**DEPARTMENT OF THE ARMY
WILMINGTON DISTRICT, CORPS OF ENGINEERS**

ORM ID SAW-2007-00157-164

Reference the Department of the Army permit issued to you on May 21, 2009, for the Rocky Mount Northern Connector, TIP R-2823, starting from SR 1604 (Hunter Hill Road) and ending at US 301, in Nash County and your written request of June 11, 2009, for permit modification. The permit modification requests are as follows:

Subject: MODIFICATION to 401 Water Quality Certification Pursuant to Section 401 of the Federal Clean Water Act and TAR-PAMLICO BUFFER RULES with ADDITIONAL CONDITIONS for Proposed Rocky Mount Northern Connector in Nash County, State Project No. 34509.1.1, TIP No. R-2823. DWQ Project No. 20081859 ver. 2.

PROJECT REFERENCE NO.	SHEET NO.
R-2823	17
RW SHEET NO.	
ROADWAY DESIGN ENGINEER	HYDRAULICS ENGINEER
REVISED 06/1/09 PERMIT DRAWING SHEET 43 OF 68

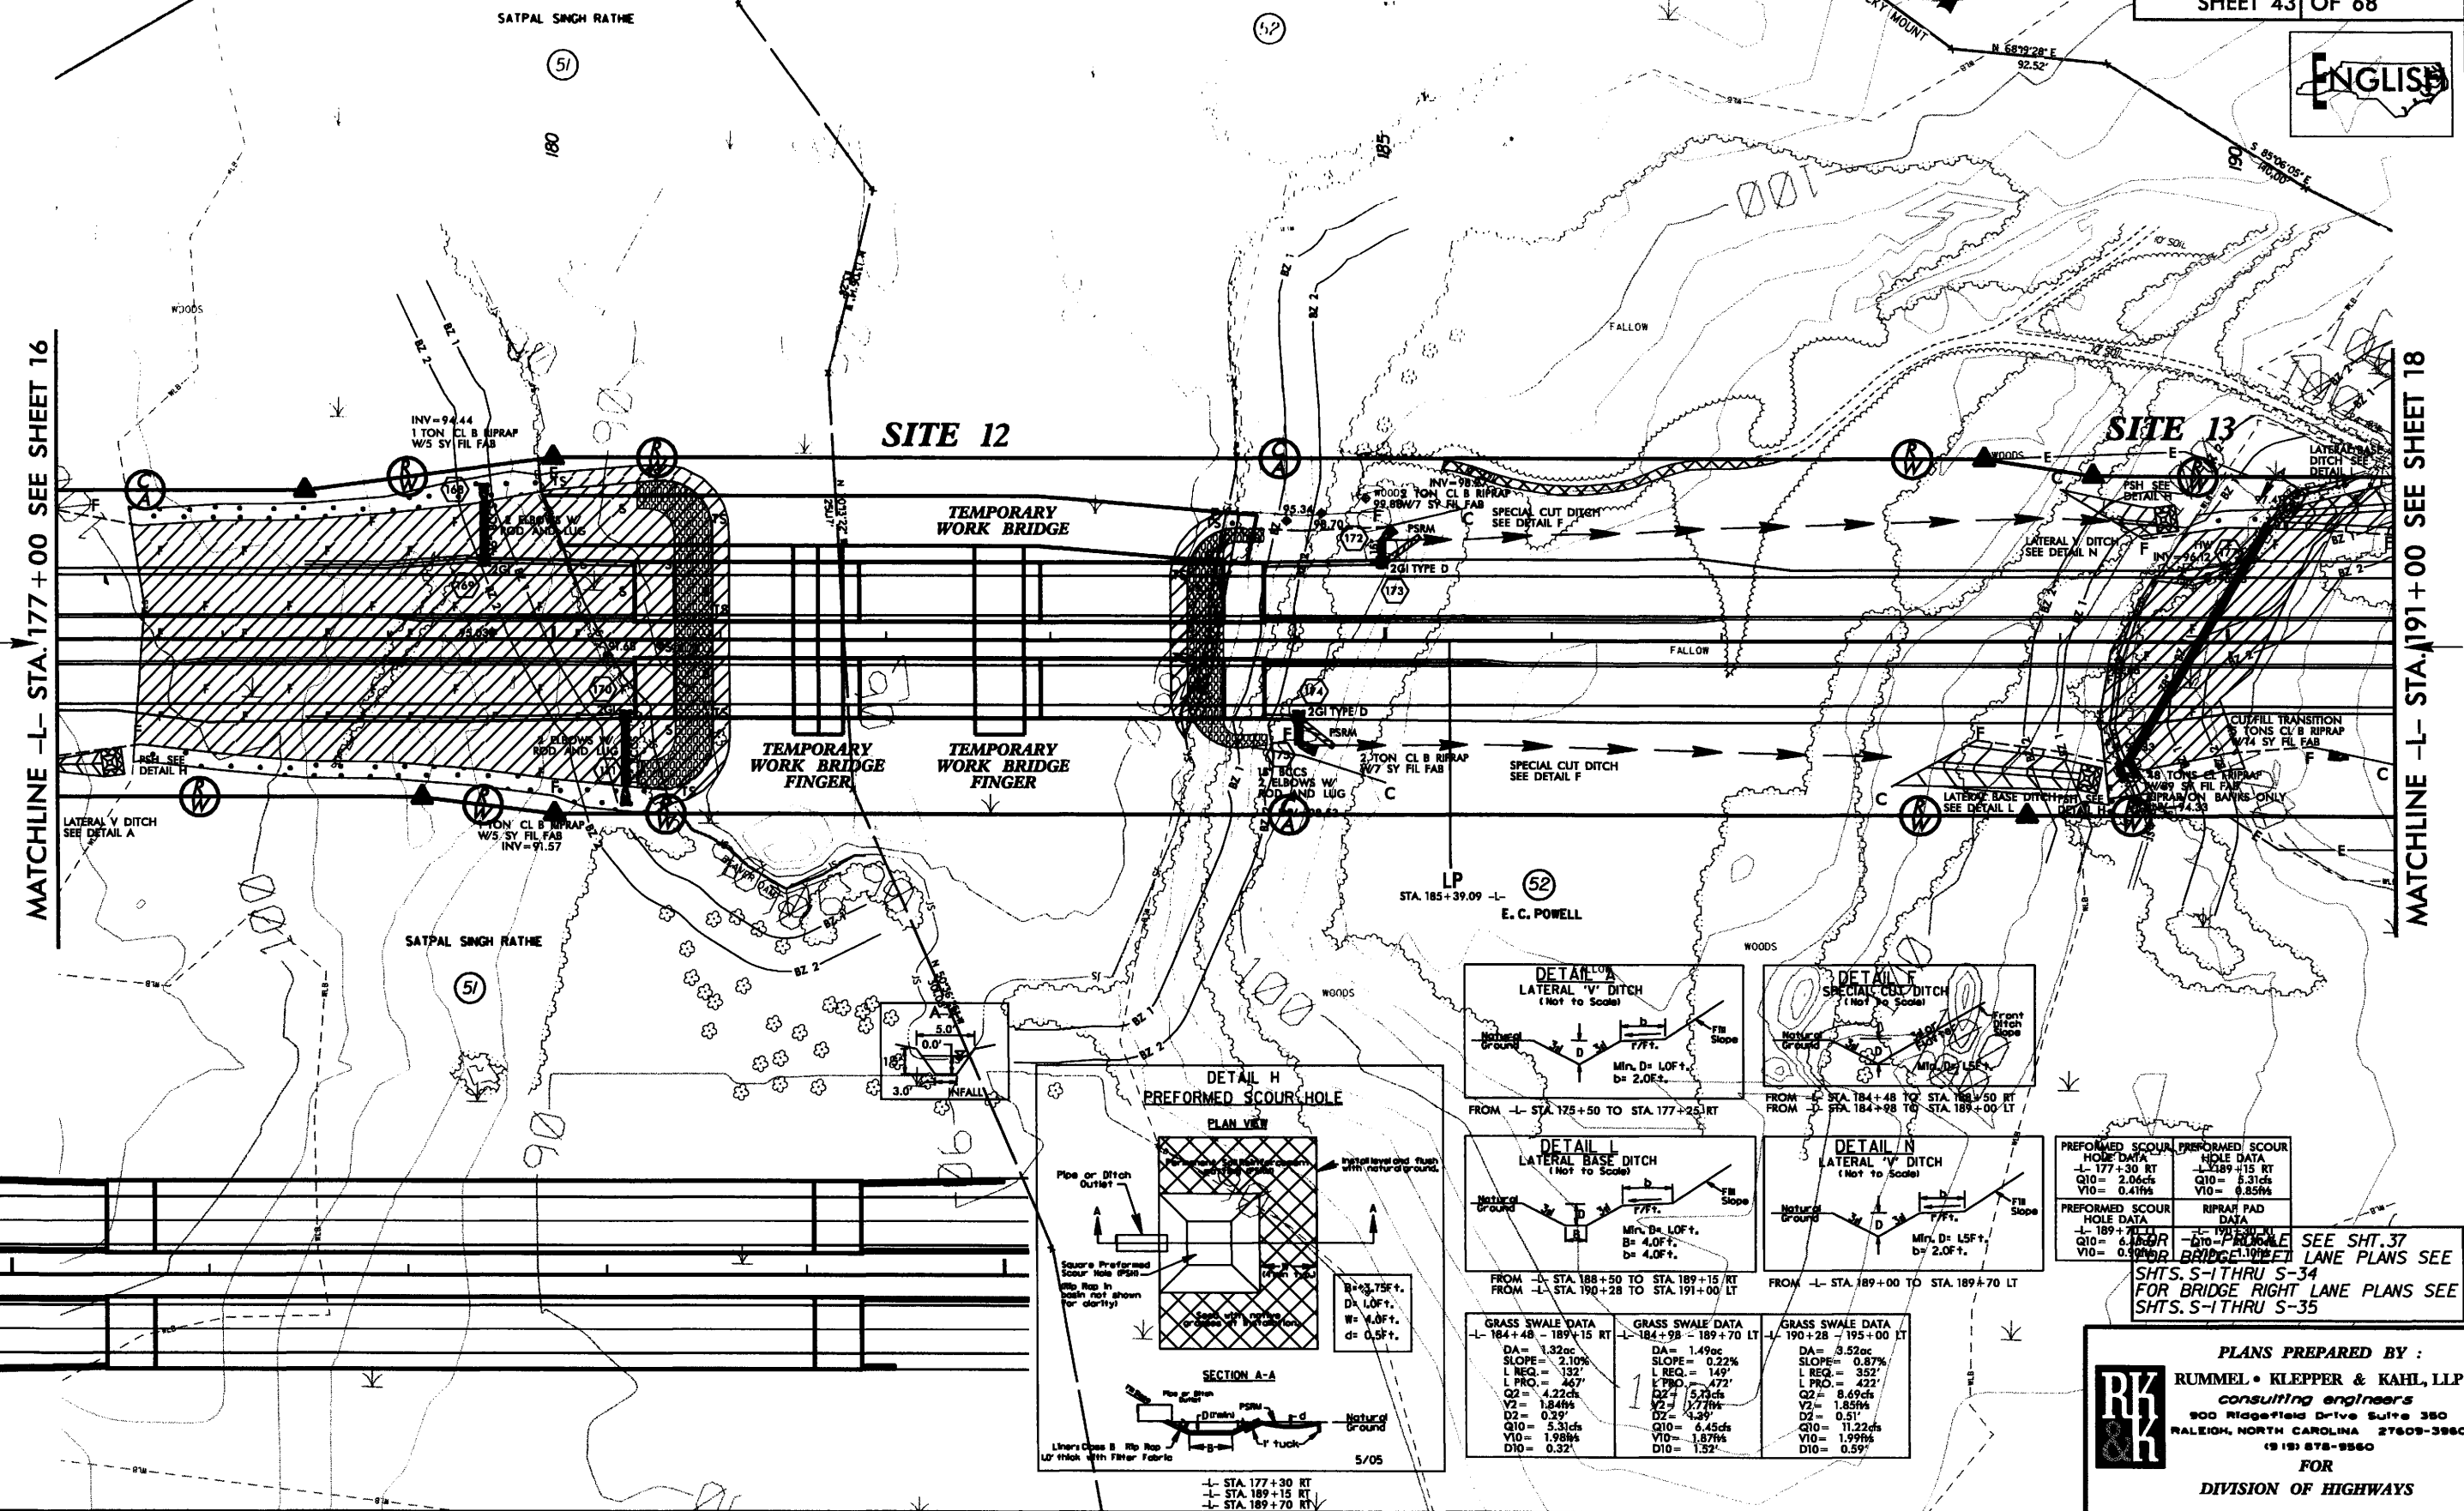
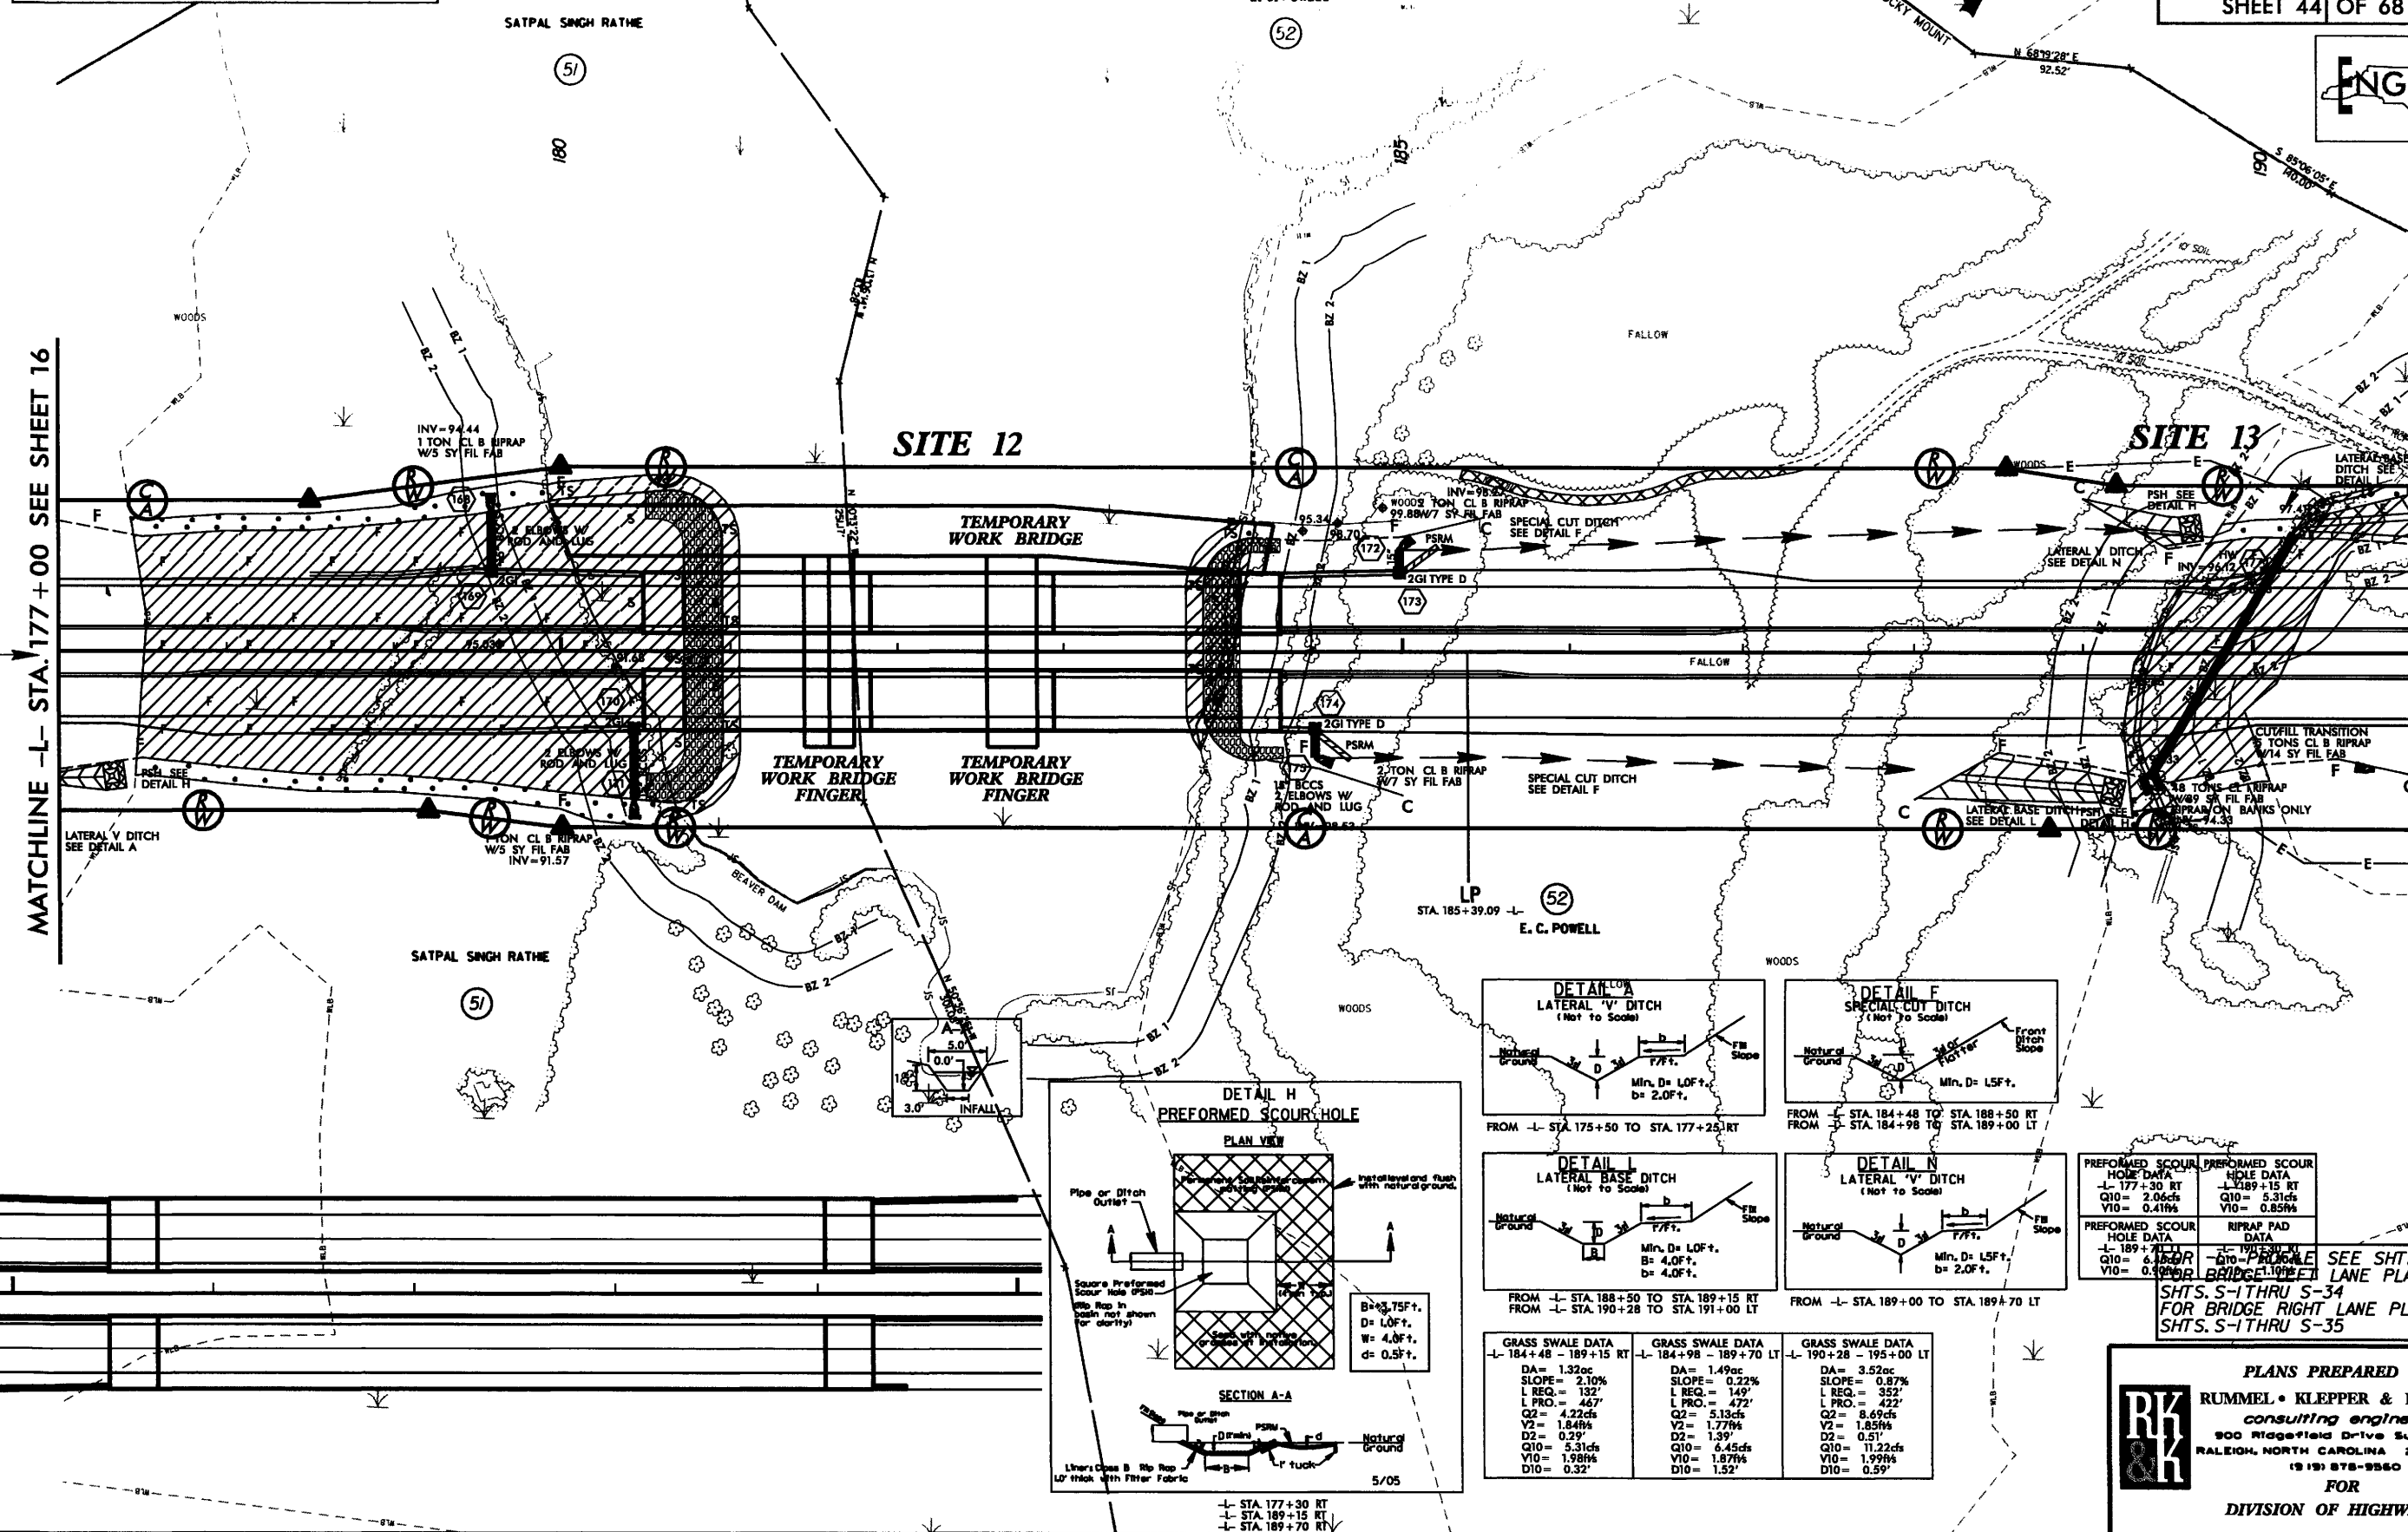
Site 1	Sheets 7 & 8	Additional wetland impacts: 0.01 acre of fill; 0.02 acre of mechanized clearing; 0.08 acre of hand clearing
Site 3	Sheets 11 & 12	Additional wetland impacts: 0.02 acre of fill; 0.04 acre of hand clearing
Site 5	Sheets 14 & 15	Additional wetland impacts: 0.11 acre of hand clearing
Site 13	Sheets 43 & 44	Additional wetland impacts: 0.05 acre of fill Reduced wetland impacts: 0.01 acre of mechanized clearing Additional stream impacts: 13 linear feet
